Date: August 9, 2022
To: City of Mercer Island – Fire Department
From: Brad Sturman
Re: Mounger Residence
4006 E. Mercer Way
Mercer Island, WA 98040
Permit # 2205-038

Subj.: FIRE CODE ALTERNATE SUBMITTAL

This letter is submitted as our request for a fire code alternate related to the permit review for the New Residence.

**SITE PLAN**  
SCALE: 1/8" 1'-0"

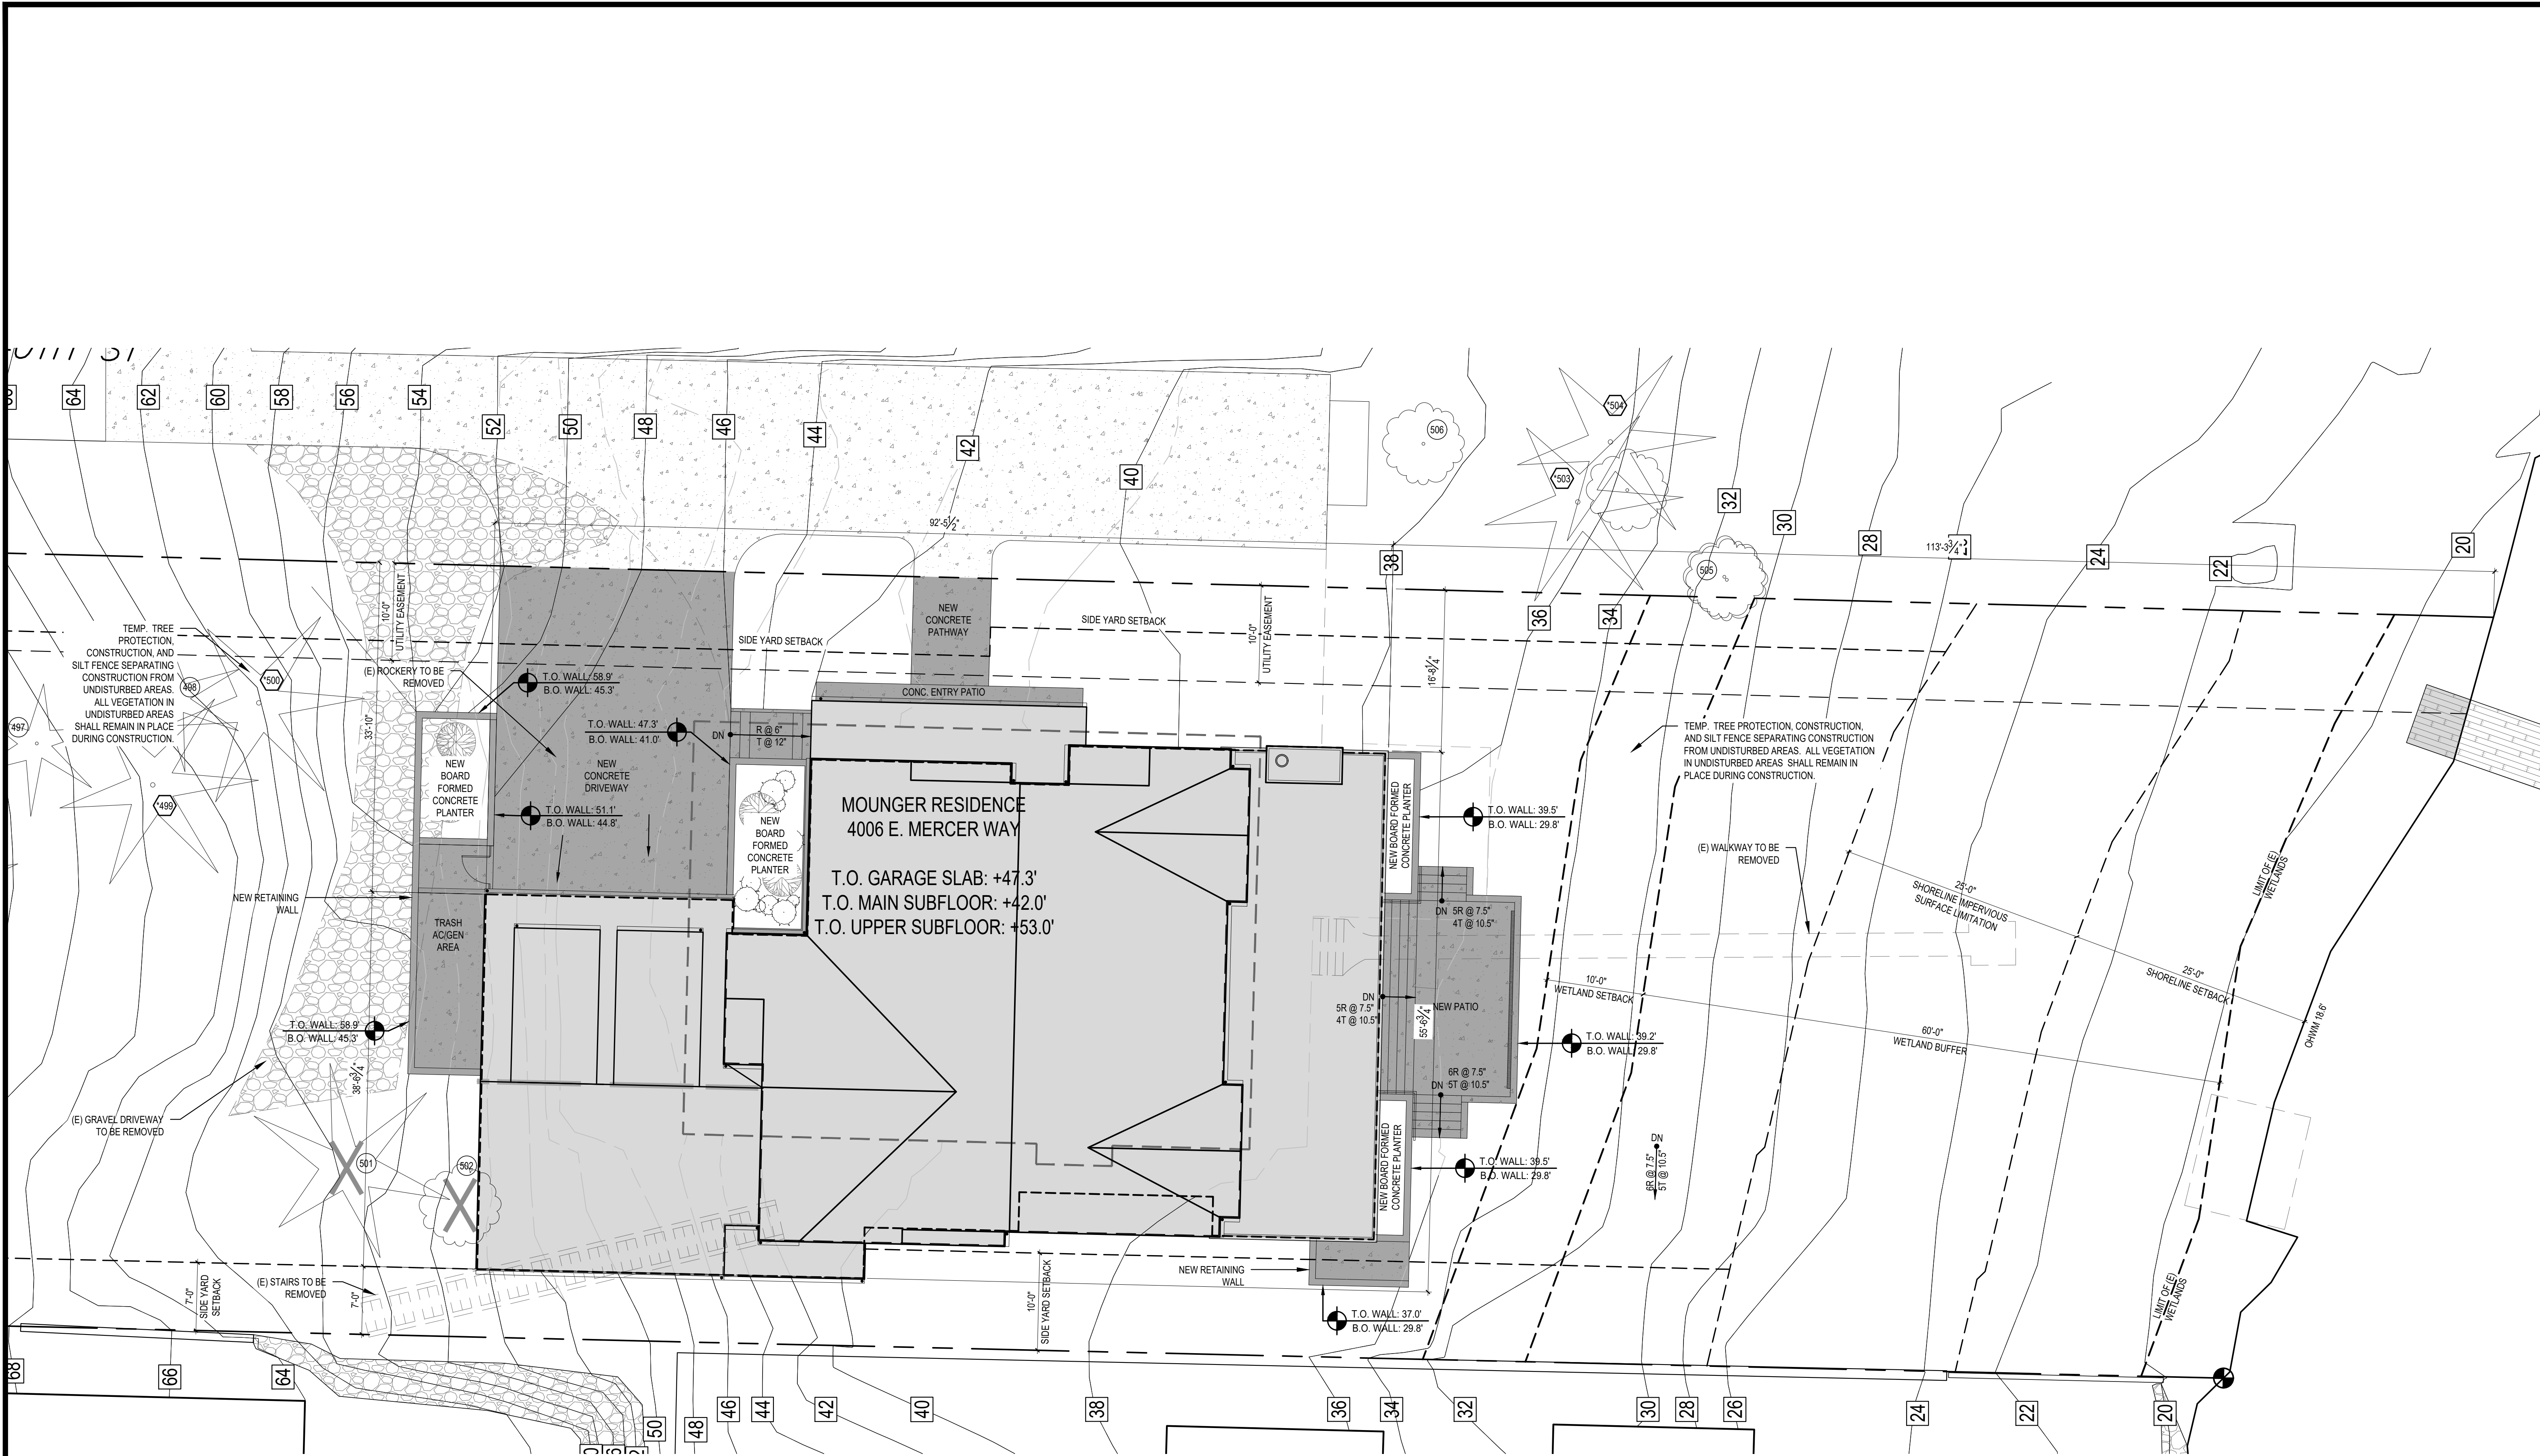
2. No-Turn around.

The 40th Avenue road terminates at the end of the 4006 property. The project proposes to replace the larger concrete area at the end of road with new concrete due to the loose and cracked condition of the material.

3. Grade exceeds 10% (must be under 20%)- Grades over 15% must be raked concrete.

The existing driveway (40th street) has high pressure gas lines underneath it. These are the main lines that feed mercer island through the lake originating on the Bellevue side.

The project calls for some minor regrading at the driveway but we are not totally rebuilding the entire road. Any new areas of concrete in the sloped zones will have a raked finish for safety.

4. Roadway Width less than 12' (under 20') Code Alt Required.

The roadway width will stay the same. The end of the roadway is wider and will receive new level concrete.
